From: [Rachael Stevie \(CD\)](#)
To: ["jackfrostloghomes@gmail.com"](#); ["craigsavio@me.com"](#)
Cc: ["Sam"](#); ["valw@apssm.com"](#); [Jeremy Johnston](#)
Subject: BL-21-00014 Frosty Pines - Deemed Complete
Date: Wednesday, June 9, 2021 2:22:00 PM
Attachments: [image001.png](#)
[BL-21-00014 Frosty Pines Deemed Complete.pdf](#)

Please see attached correspondence regarding your Boundary Line Adjustment application. I have mailed hard copies as well.

SHEET

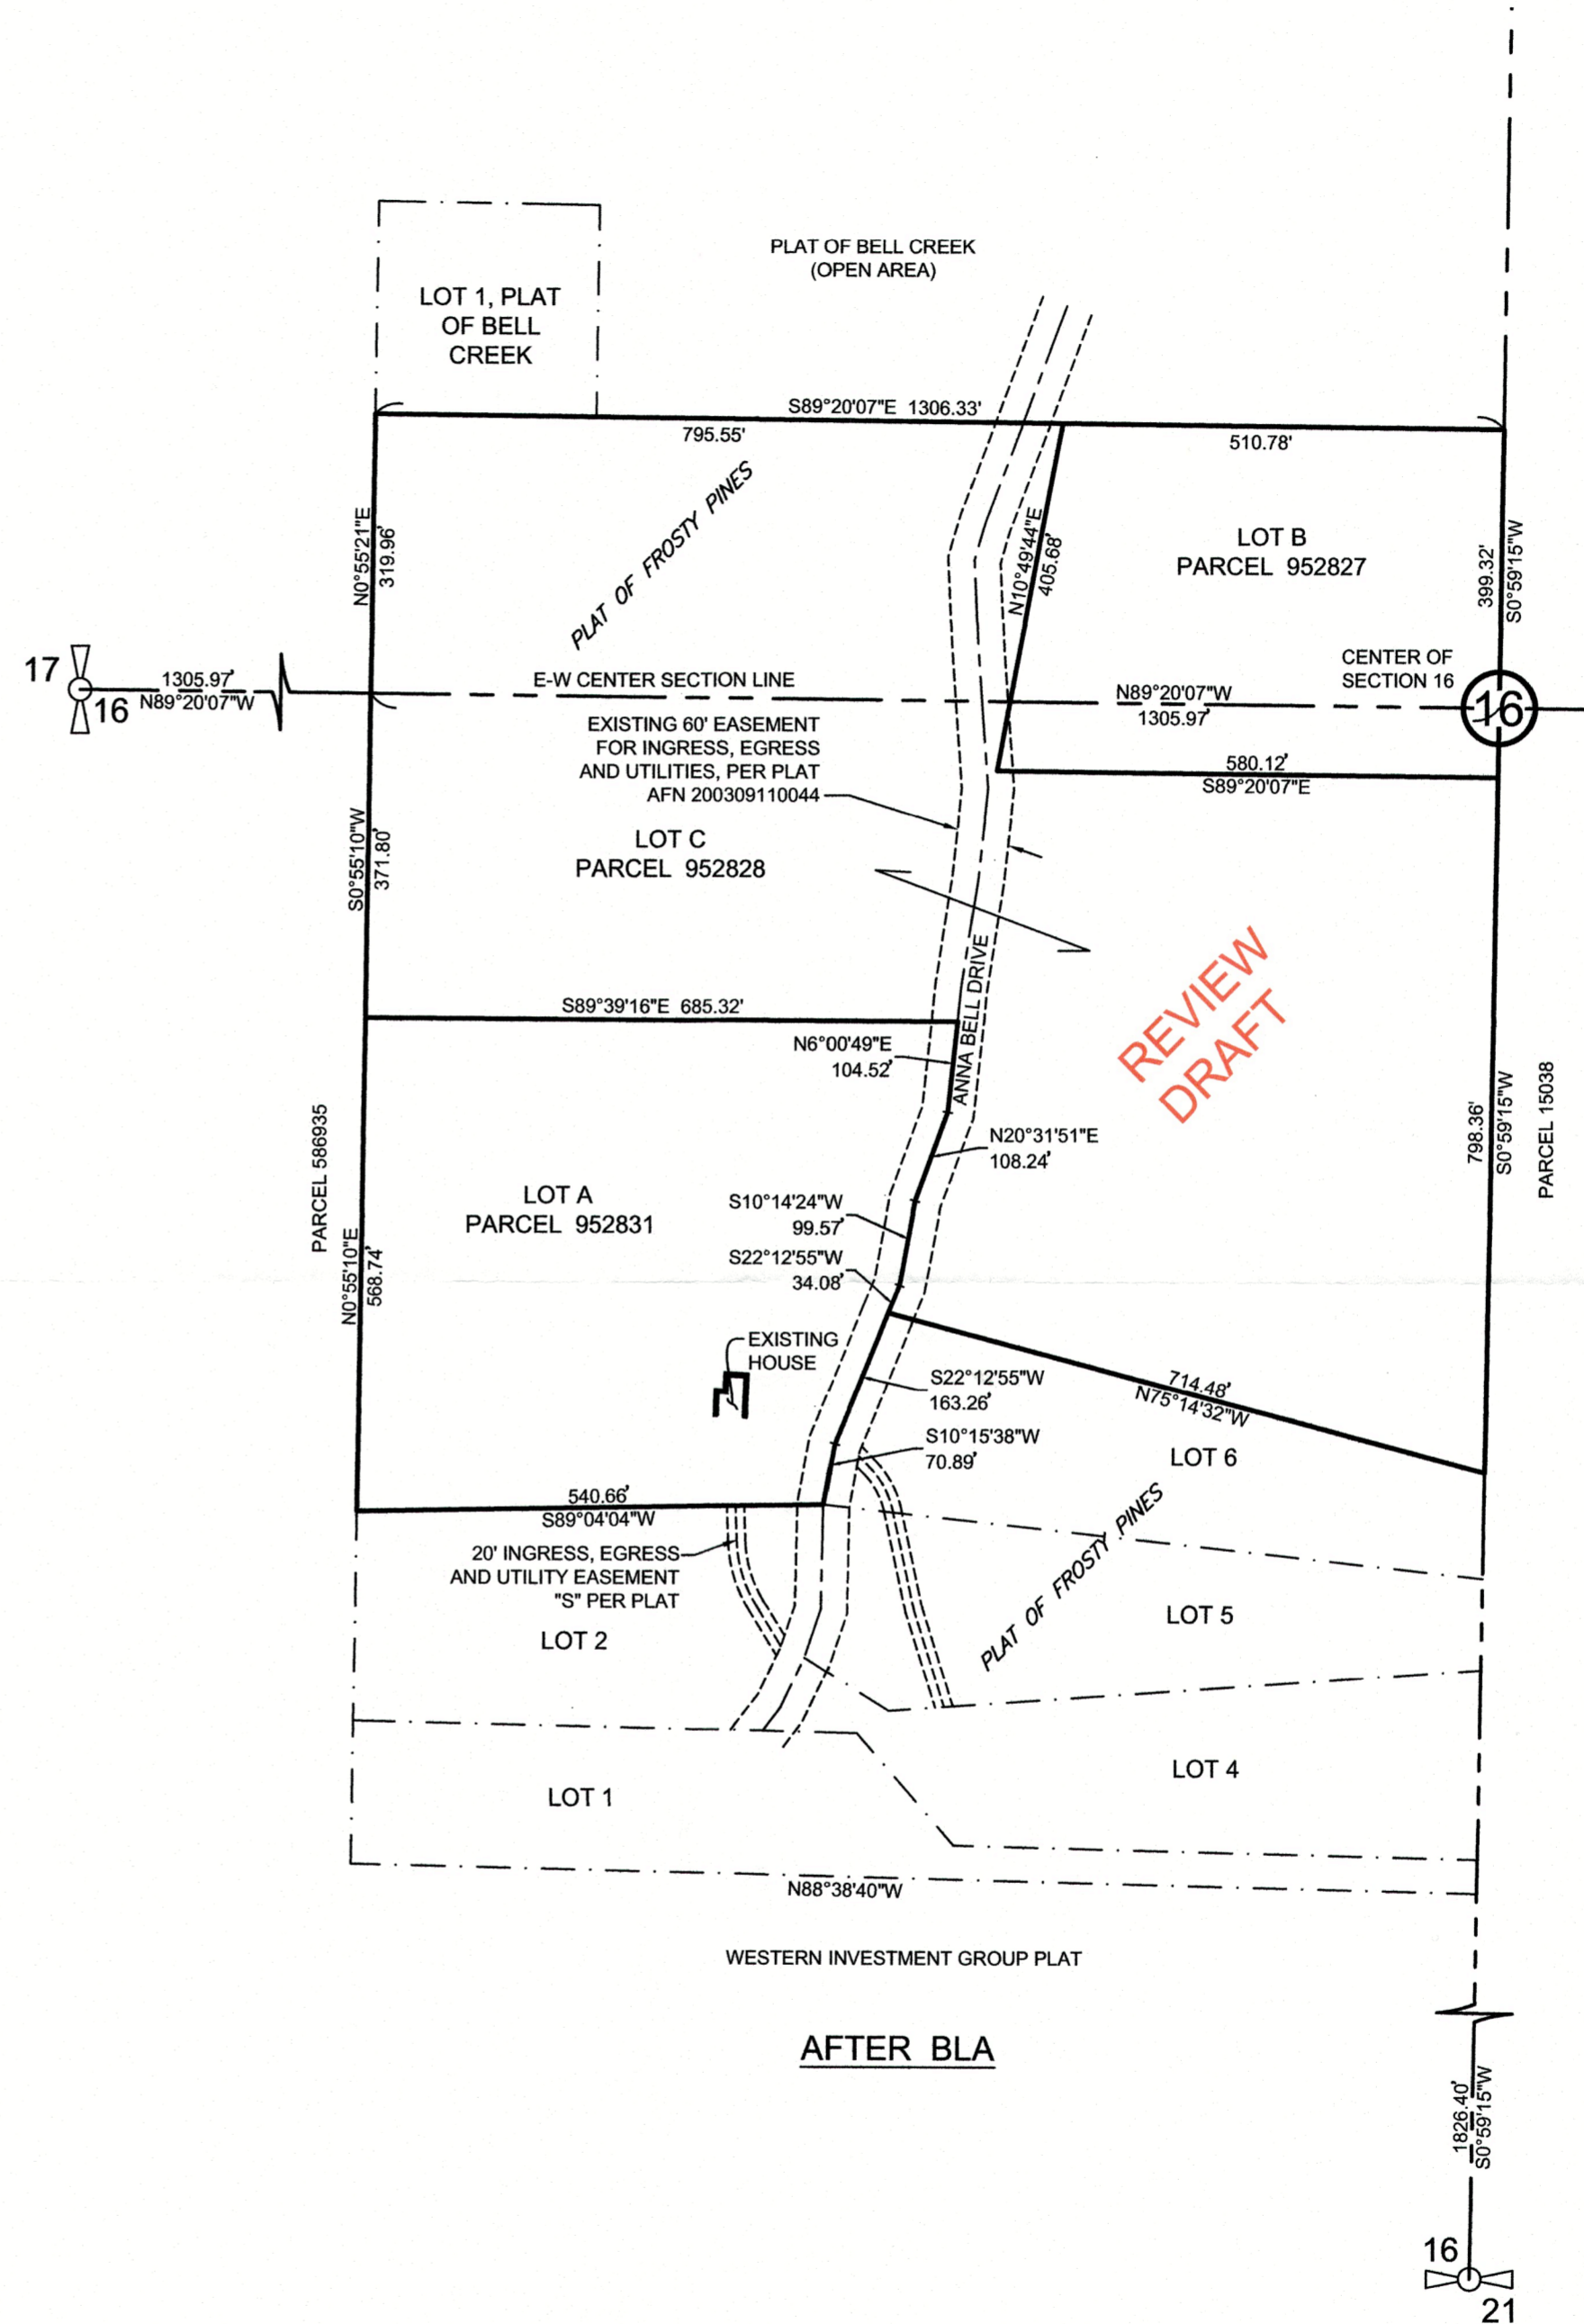
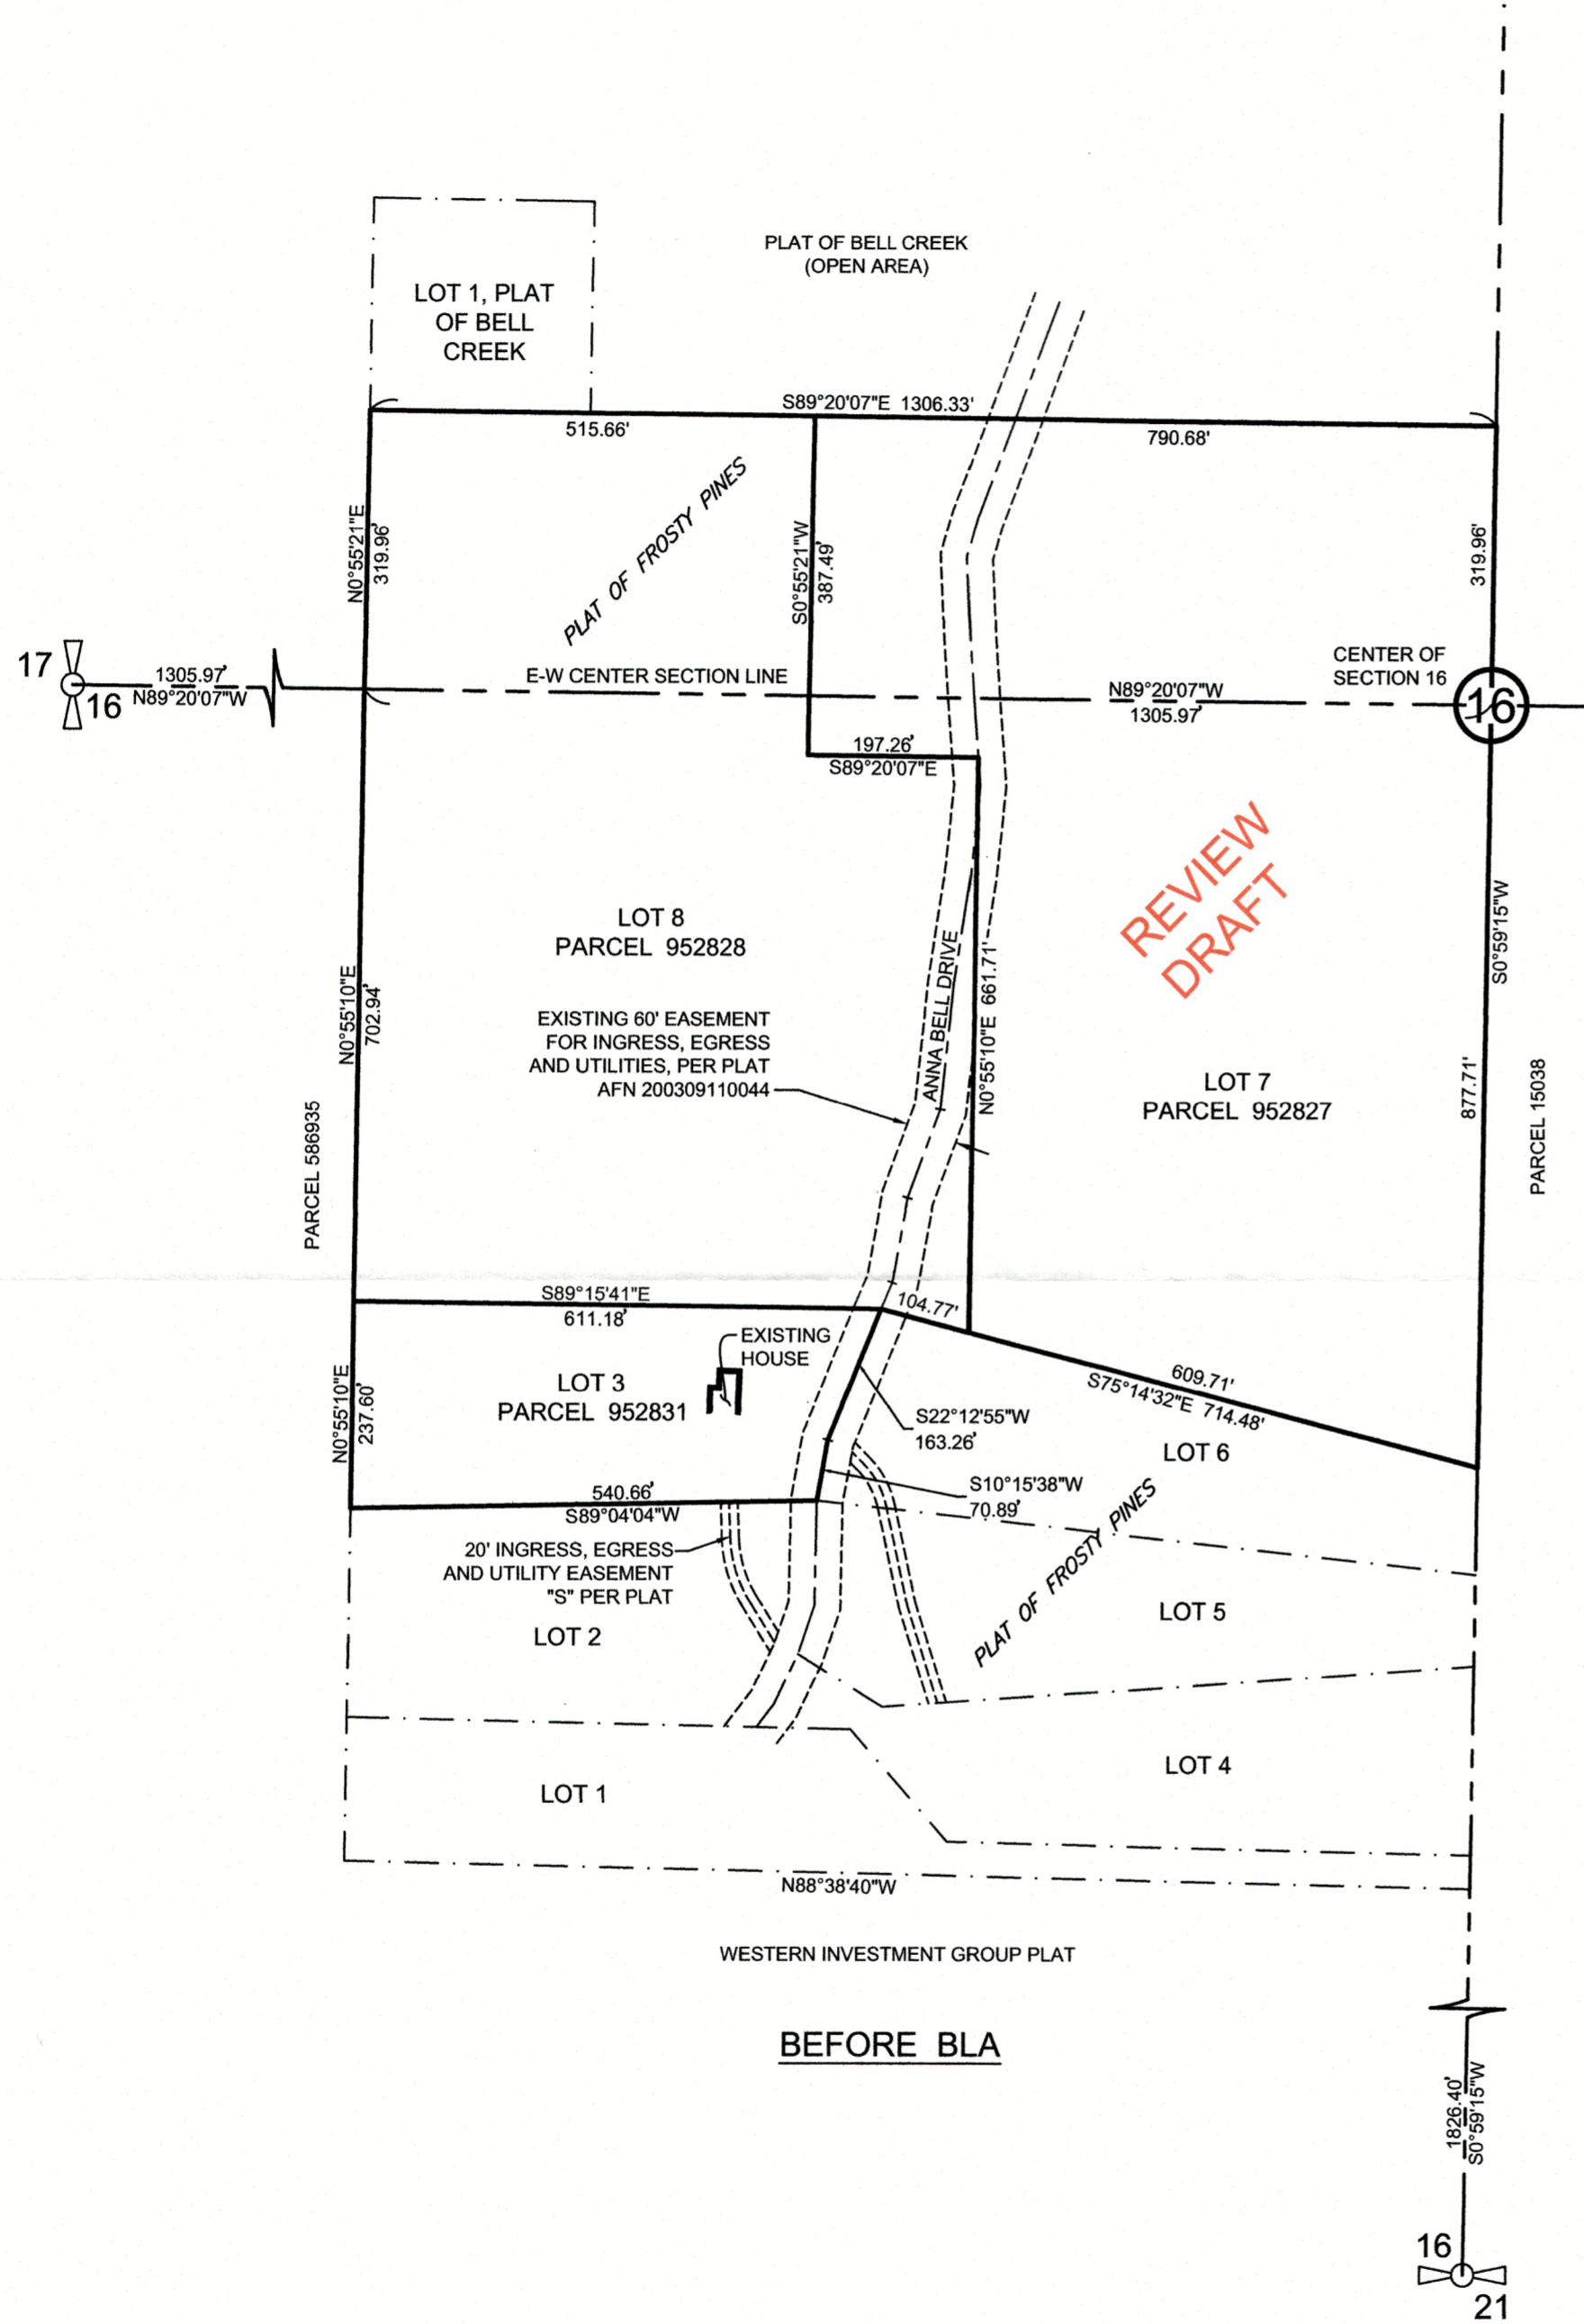
I am also requesting that you provide an updated site map with the location of any well and septic systems identified. I am asking preemptively because I know Public Health will request that information before their review.
